RE: Case Reference: 320916, 320095 and 320094

Applicant: Coolpowra Flexgen Limited

Development: BESS, GAS Plant and GIS Substation

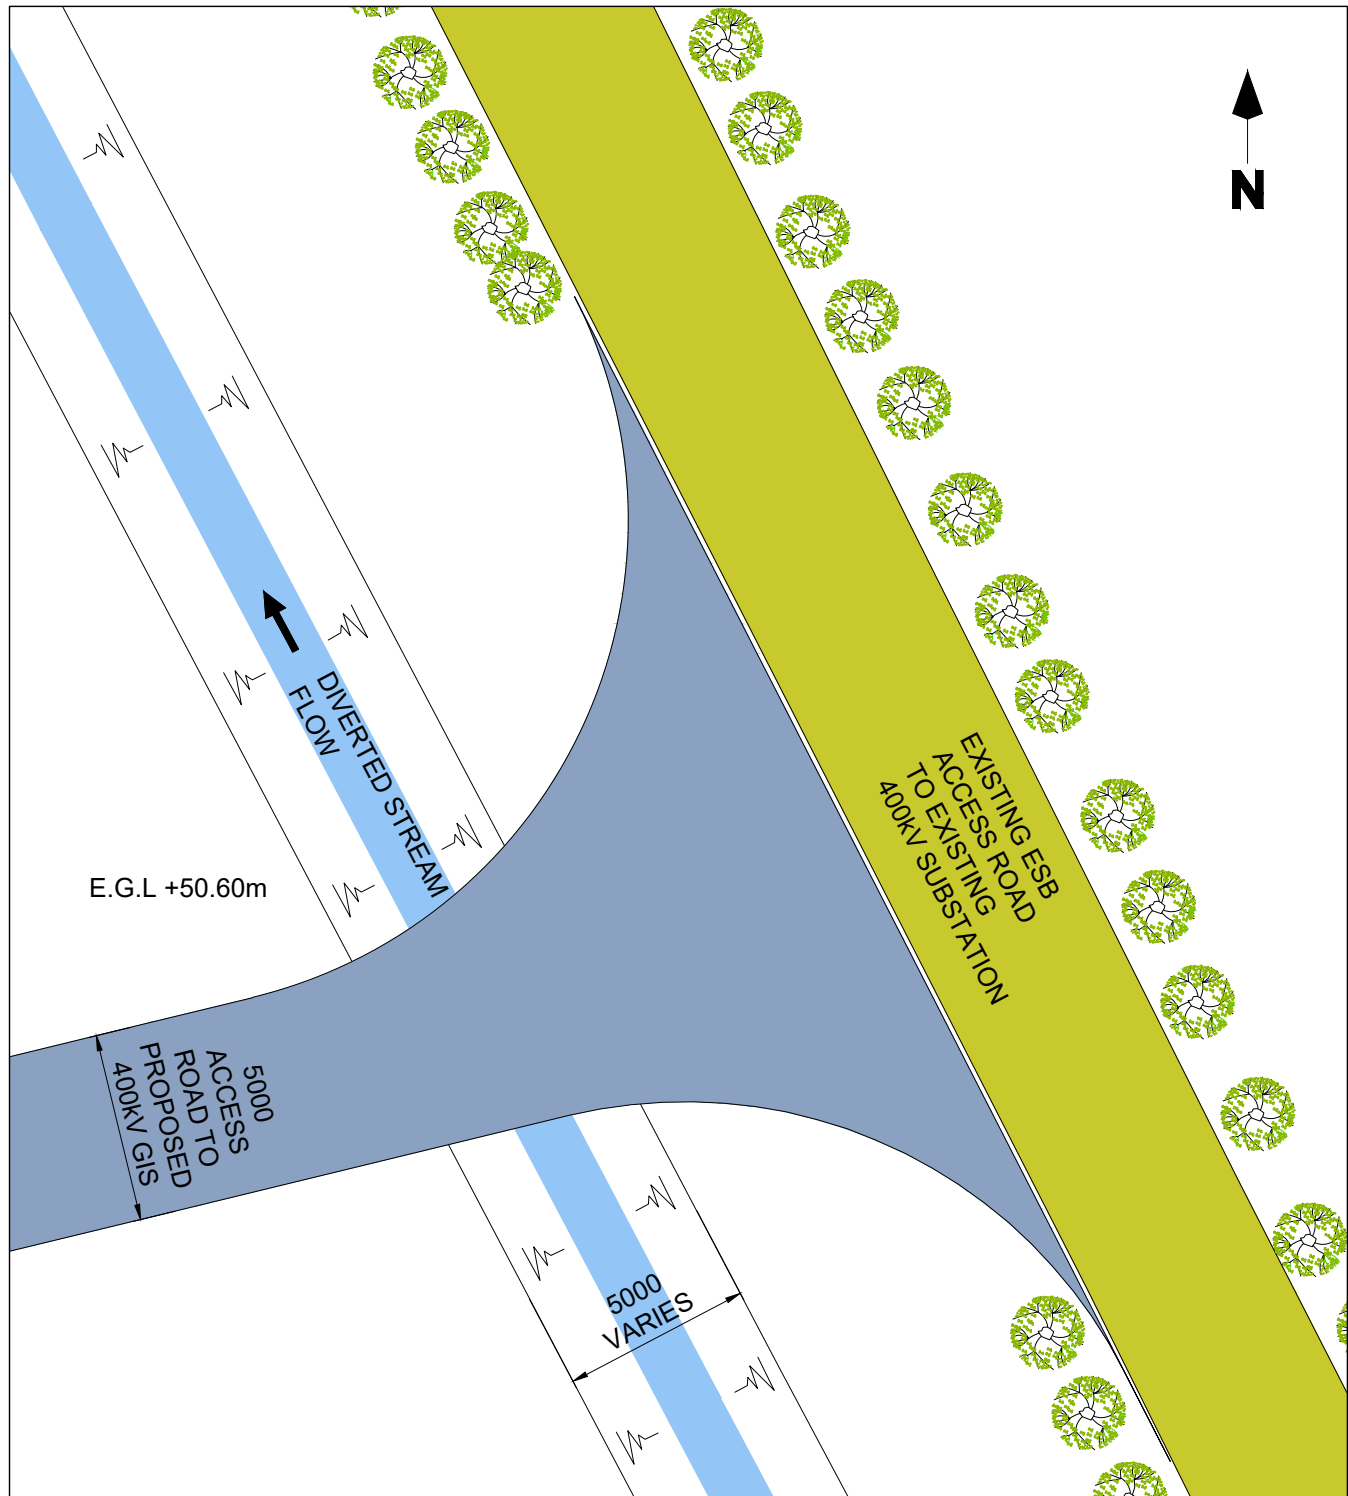
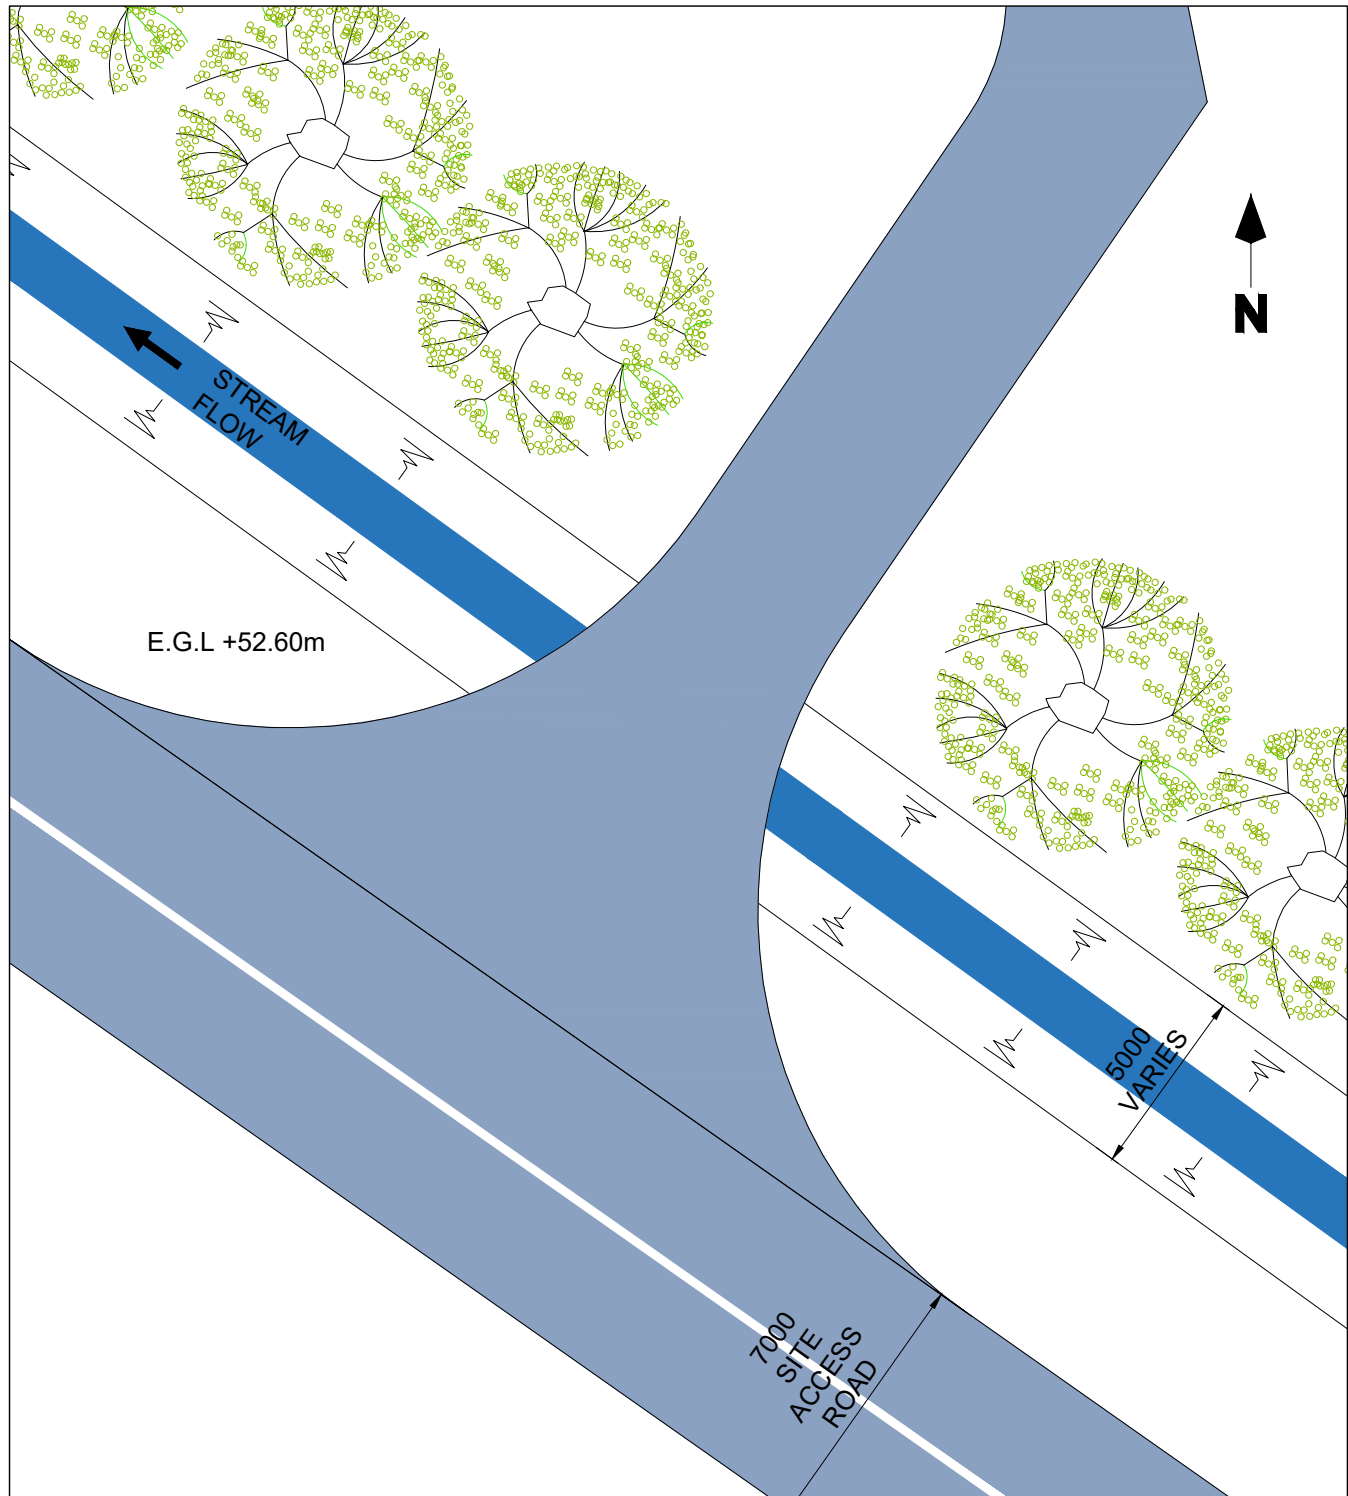
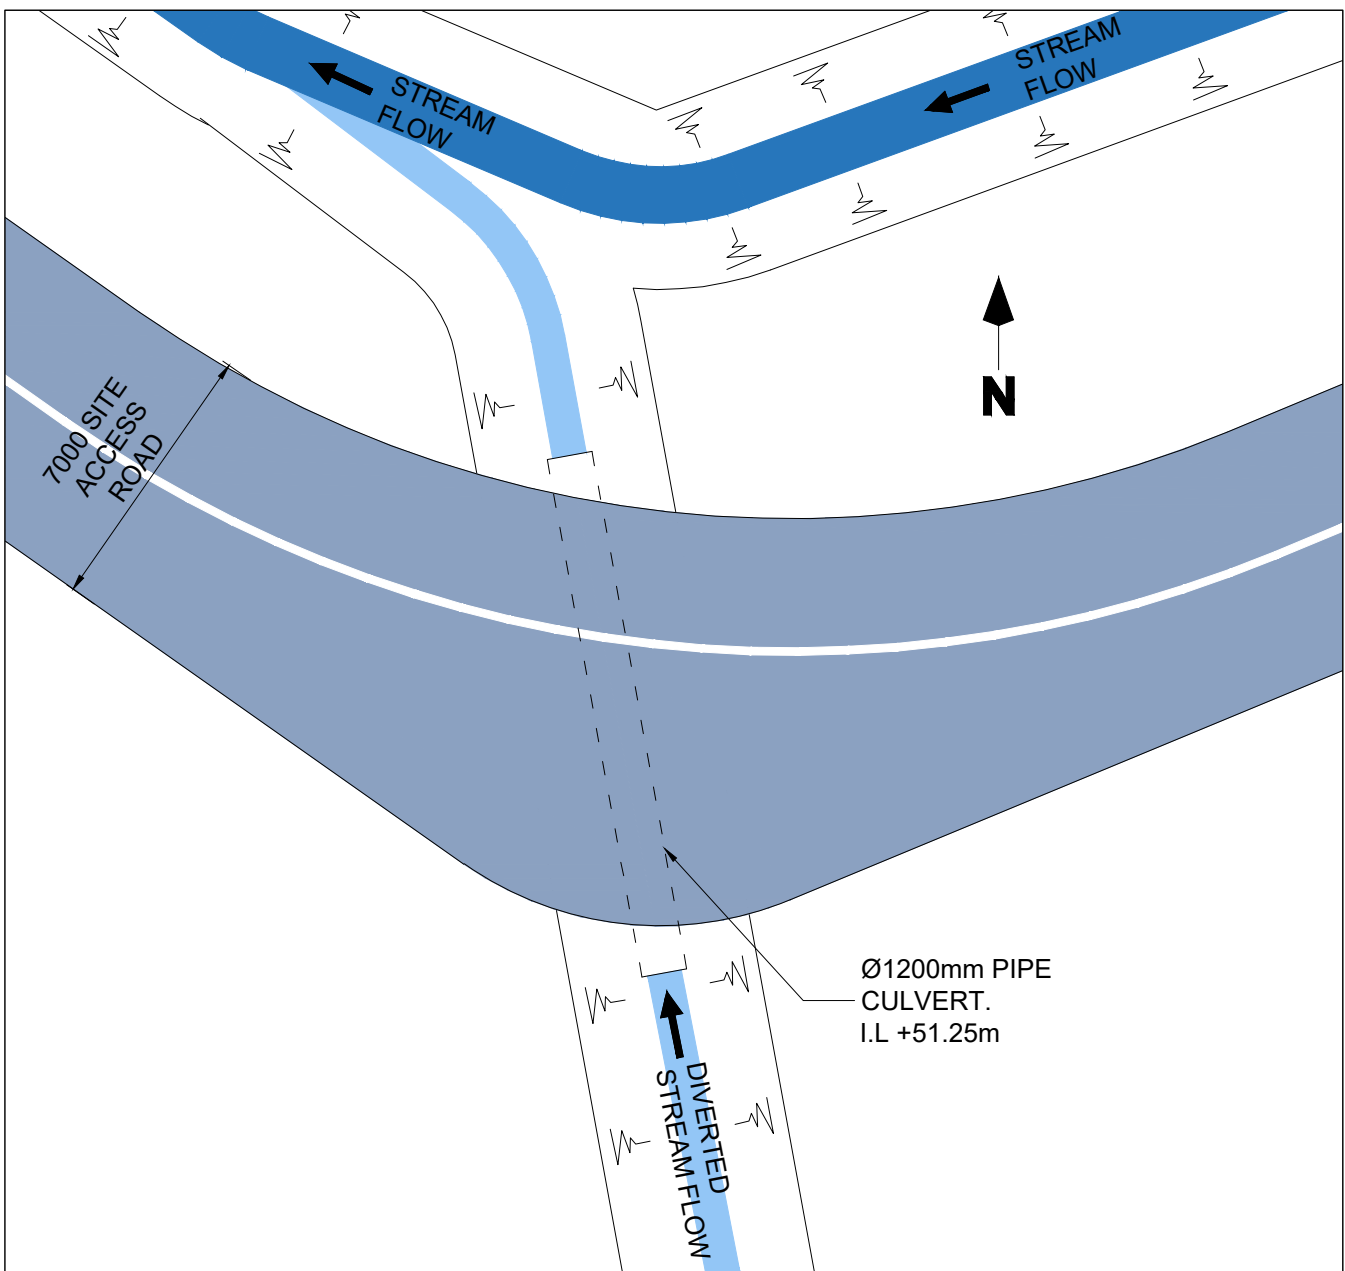
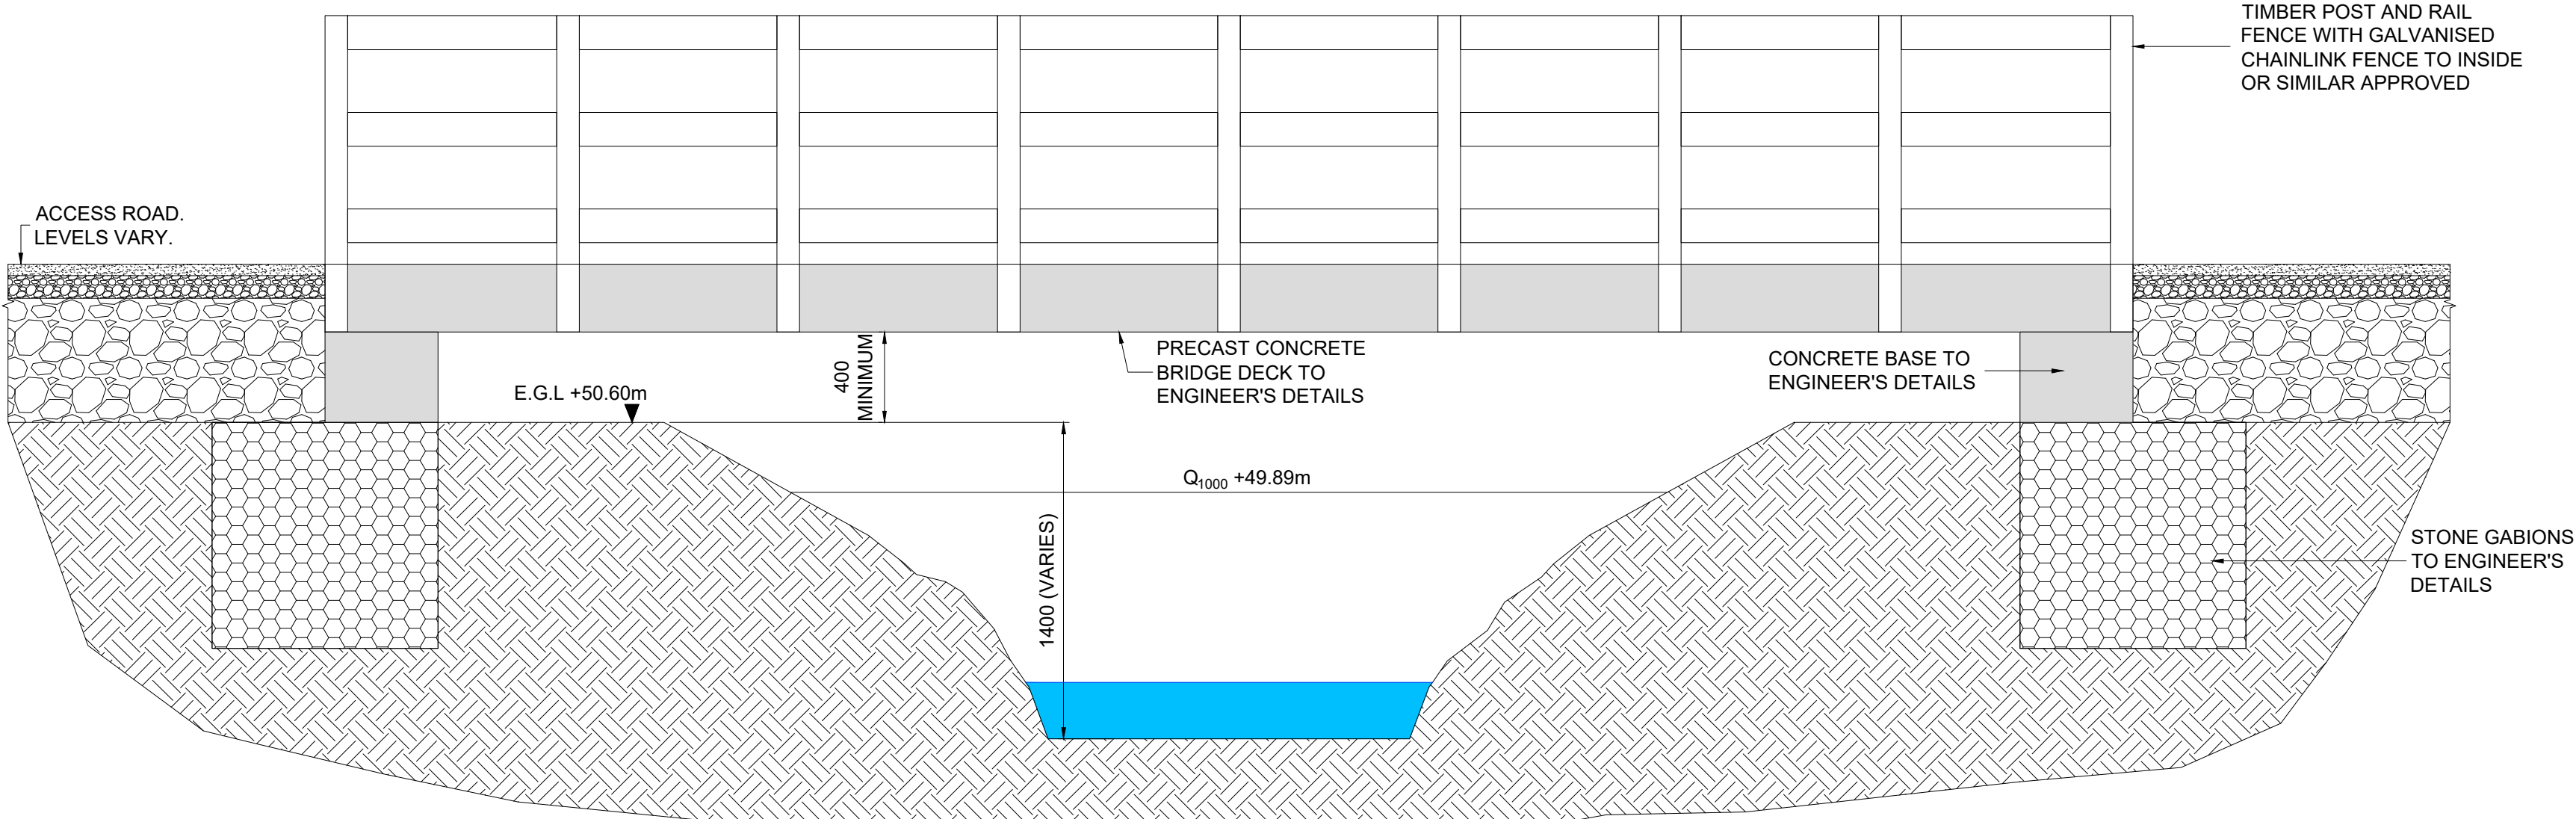
- **Redirection of Treananearla stream:** redirecting a small section does not avoid that fact that the majority of this stream will still travelling through the centre of this large scale site, in particular closely bordering 2 sides of the BESS. Should there be a fire at the battery facility (which is not uncommon in Ireland eg Claregalway) the stream will be directly hit.
